Re: Planning Application 20/0803

Address: Land off Clitheroe Road Whalley BB7 9AQ

Description: Approval of all reserved matters including appearance, landscaping, layout and scale following outline planning permission 3/2019/0907 for one new dwelling and associated works.

Land off Clitheroe Road, Whalley - Floor Plan

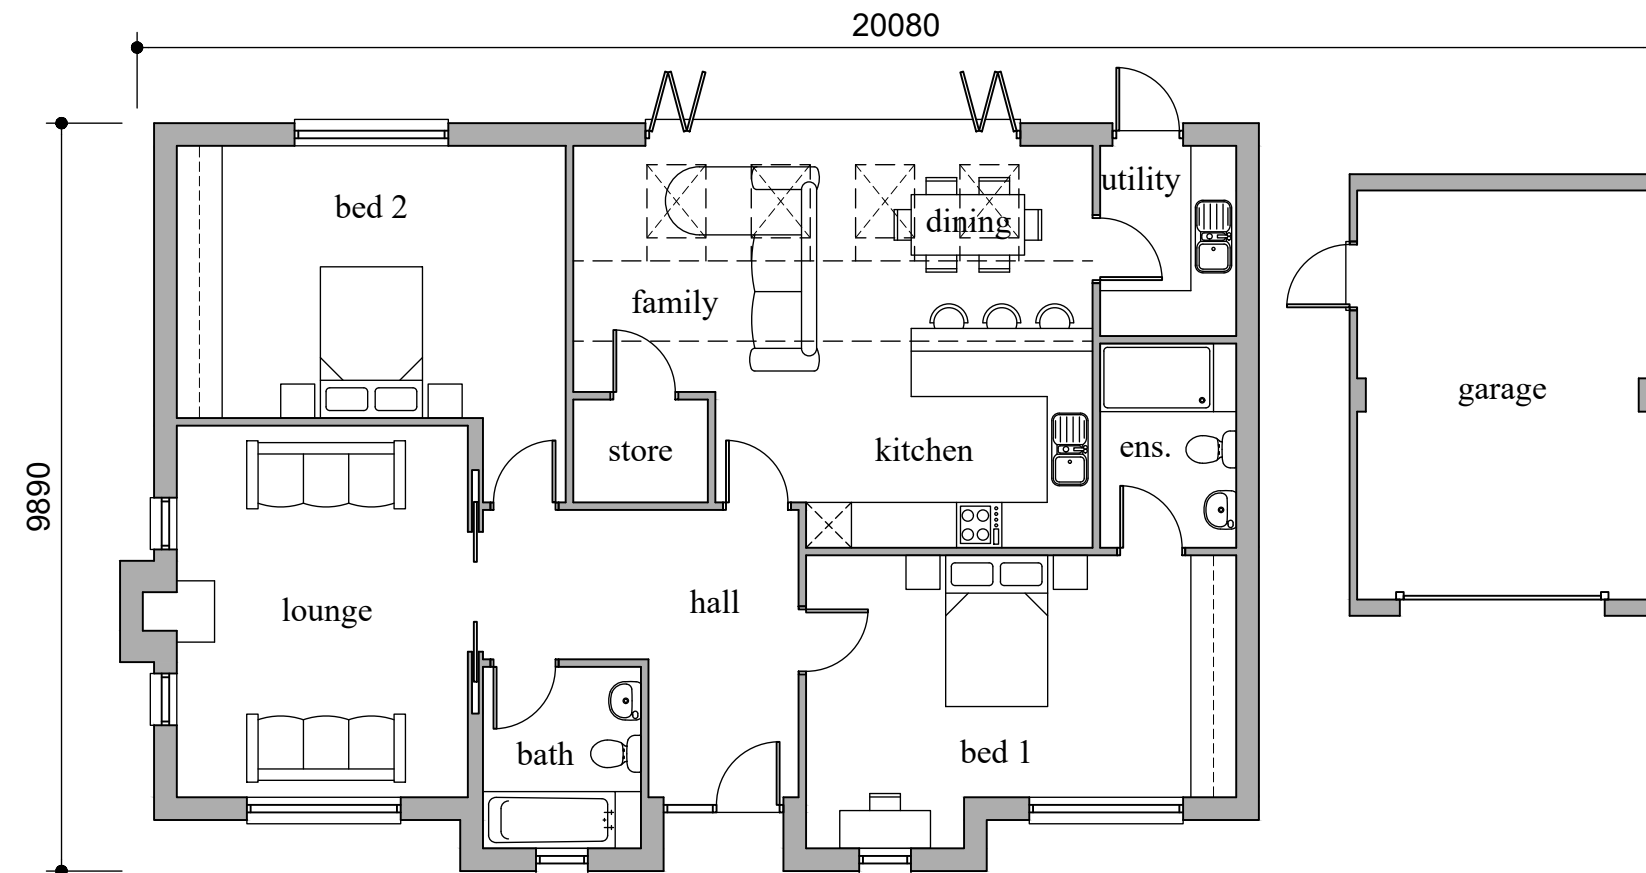
It is noted that the driveway is proposed as two parking spaces, the garage shown on the plans is not considered to be a parking space as it does not conform to the guidance given in Manual for Streets, which would suggest that a garage should measure 3m by 6m internally. Due to the slightly shortened driveways care should be taken that the garage door does not extend beyond the floorplan whilst opening, so as not to damage any vehicle parked on the shortened driveway. It is also noted that there is still no private footway between the driveway and the access path to the front door of the dwelling, thus forcing the residents to walk on the carriageway.

## Land off Clitheroe Road, Whalley - Landscaping Plan

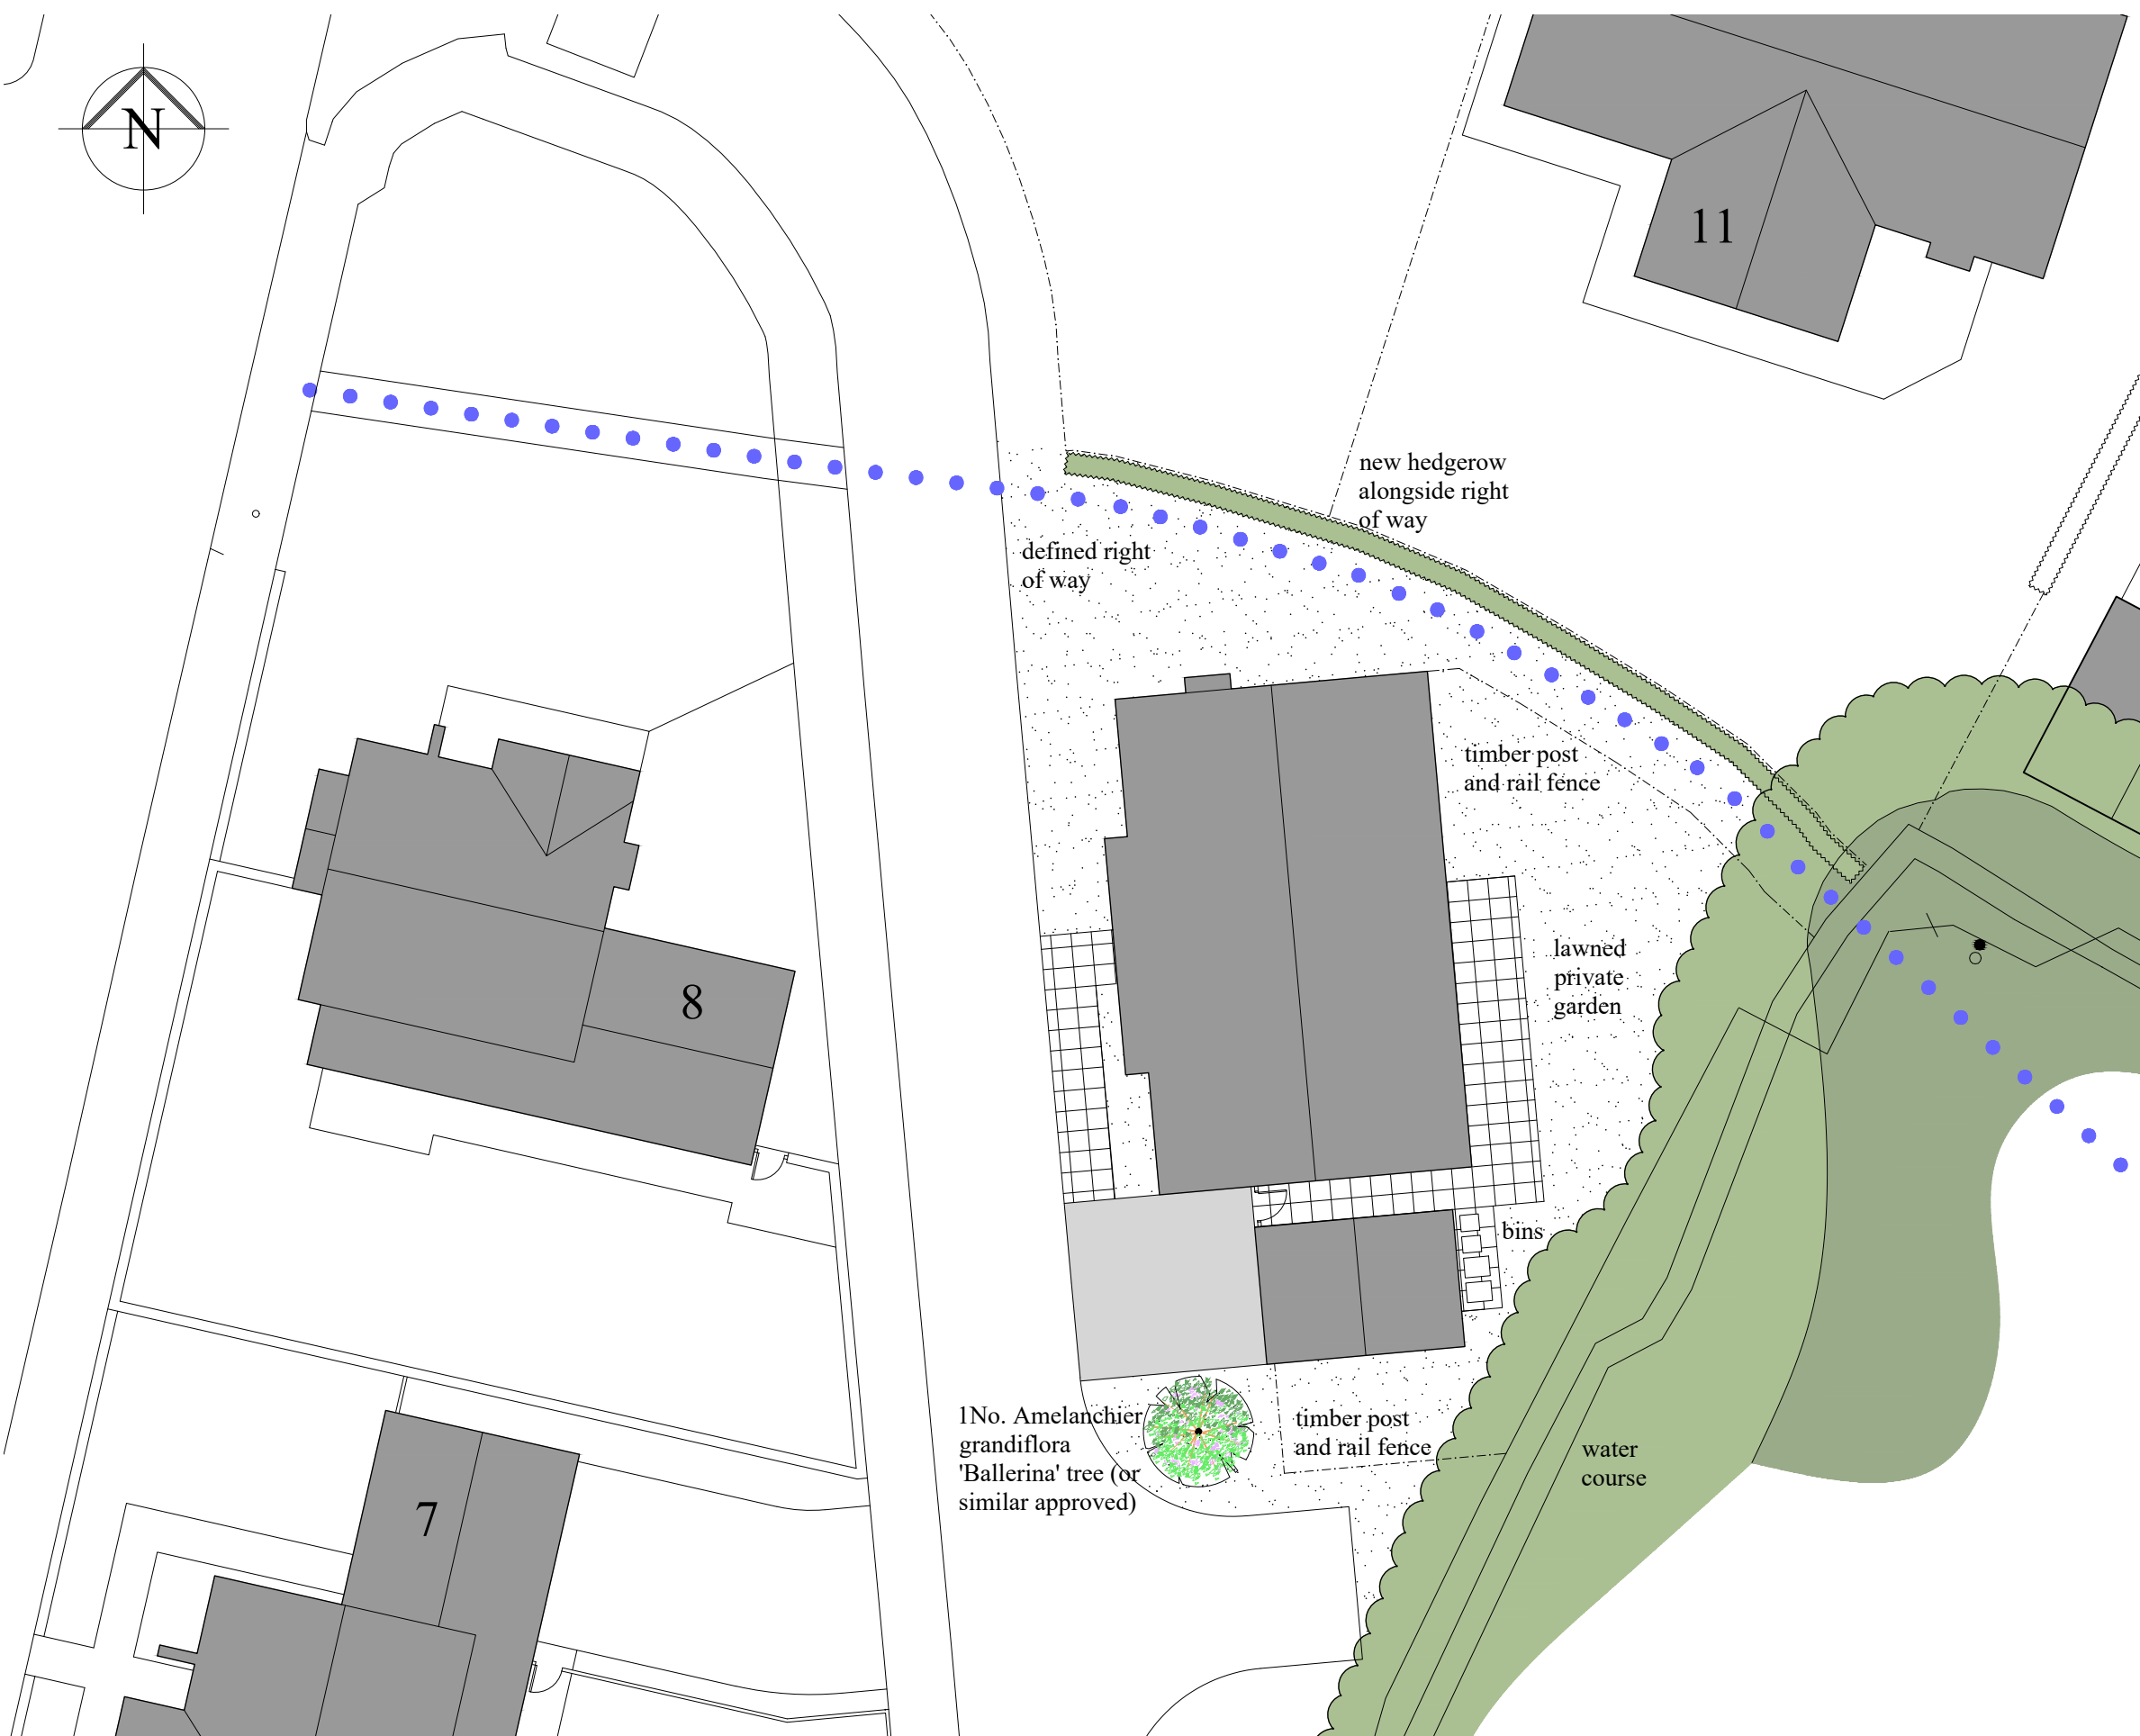
1. Before the access is used for vehicular purposes, that the driveway extending from the highway boundary shall be appropriately paved in tarmacadam, concrete, block pavements, or other approved materials. **Reasons:** To prevent loose surface material from being carried on to the public highway thus causing a potential source of danger to other road users.
